Application Ref: H17-0004-26

Proposal: **Demolition of existing building and erection of 3 new dwellings**

Location: **1 Park Lane, Surfleet, Spalding, PE11 4AF**

Requests that the Local Planning Authority request the applicants to provide additional information as set out below.

PROPOSED BLOCK PLAN

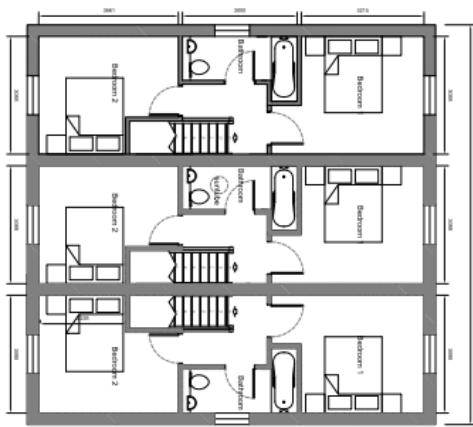
I have significant concerns with vehicles reversing onto the B1356 Surfleet Road at this location. Visibility is poor due to the presence of the bridge and the level difference from the site to the public highway. I would suggest that an alternate layout is proposed to utilise only one access from Park Lane.

Existing street furniture needs to be detailed on the proposed site plan.
